38 LEVERTON AVENUE
FELPHAM
BOGNOR REGIS
WEST SUSSEX
PO22 7RA

4 July 2019

Planing Ref FP/100/19/HH

PROPOSED GROUND FLOOR

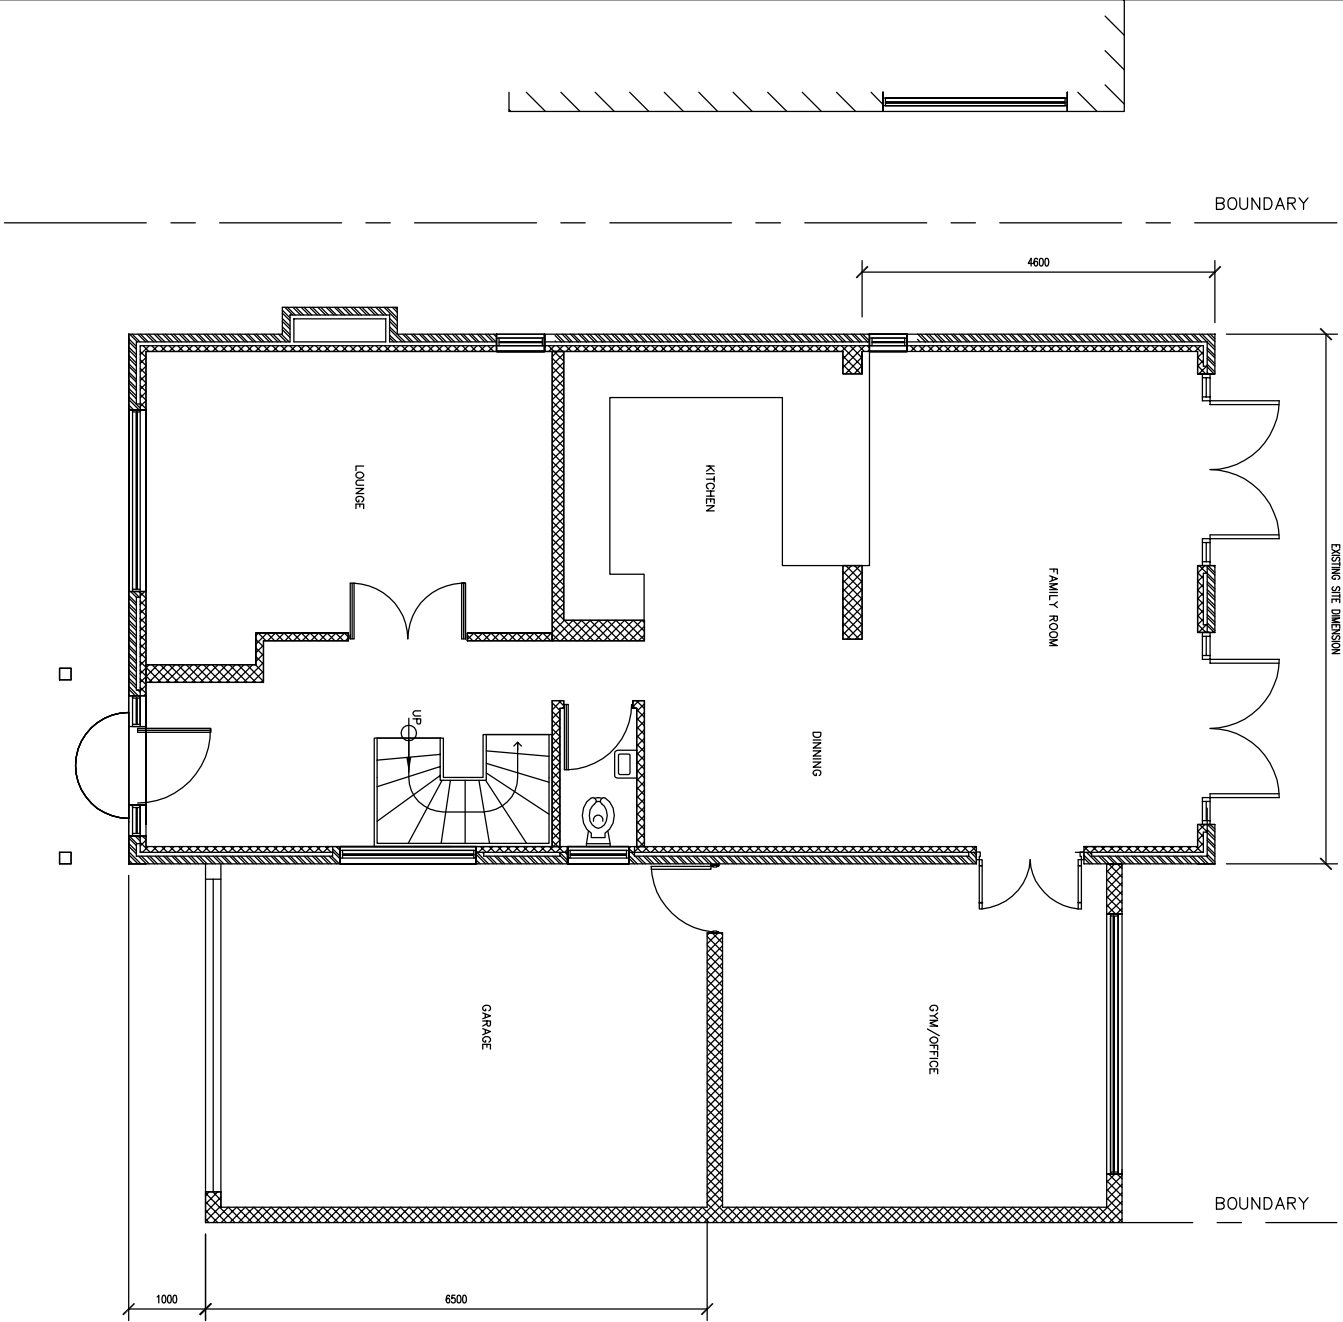
1. On the proposed ground floor plan it is indicated that the garage wall belongs to No 40 Levertton Avenue, according to my deeds that boundary belongs to No 38 Levertton Avenue, this wall is a party wall which is not mentioned on the drawing.

2. In front of the existing garage there is sewer man hole cover that serves No 40 and also No 38 Levertton Avenue, if this extension goes ahead it will no longer be accessible without access to the garage, this could cause problems for me and also future owners and purchasers of No 38 Levertton Avenue, what is going to be done to address this potential problem.
